Arun District Council
Arun Civic Centre
Maltravers Road
Littlehampton
West Sussex BN17 5LF
Planning & Building Control General Enquiries
Tel: (01903) 737756 Fax: (01903) 730442
Dx: 57406 Littlehampton
Minicom: 01903 732765
e-mail: planning@arun.gov.uk
website: www.arun.gov.uk/planning

Application for Planning Permission for Works or Extension to a Dwelling

Development Rear and side two storey extensions and alterations. Resubmission of AL/102/11
Location 2 New Cottages Lidsey Road Bognor Regis

Block Plan I : 500

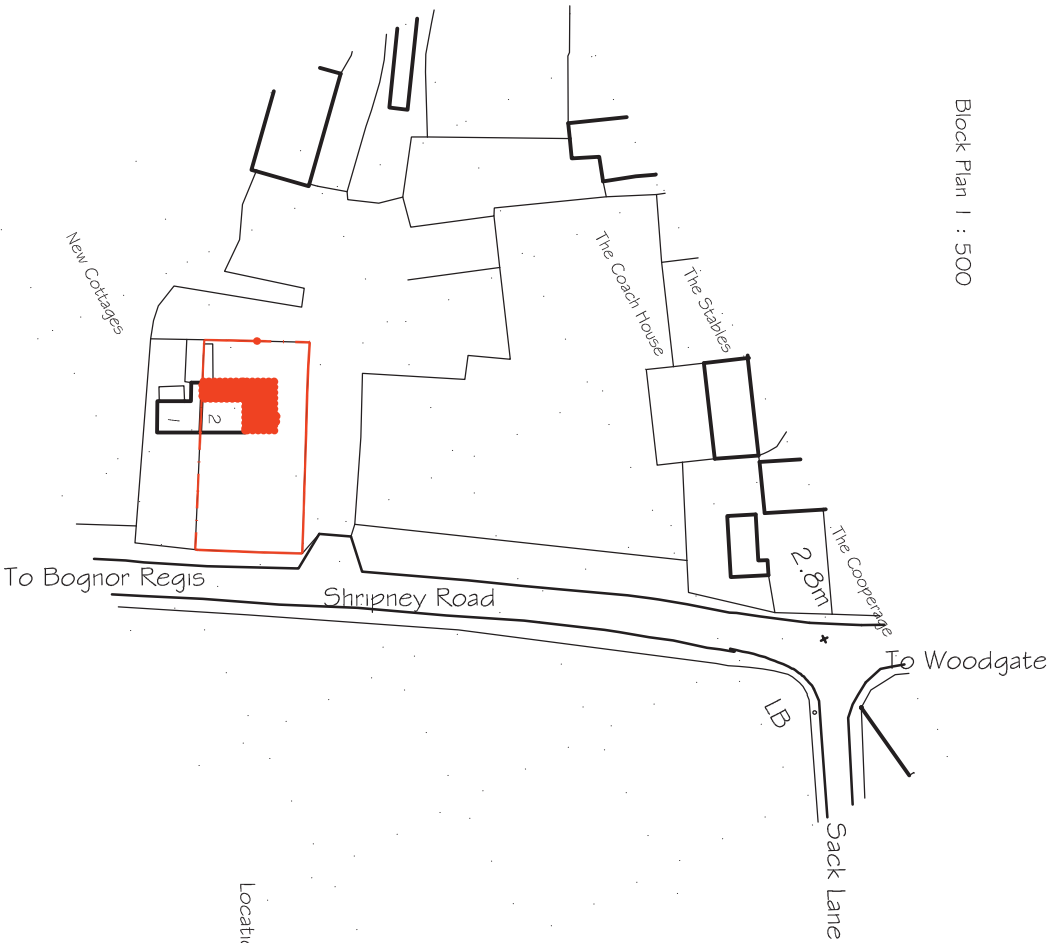
- ✓ Please submit 1 electronic or 3 paper copies of a revised block/site plan to include 1 named road in accordance with the guidance notes available on our website detailed below (click on National List). I have enclosed a copy of your Block plan for you to amend and then return accordingly.
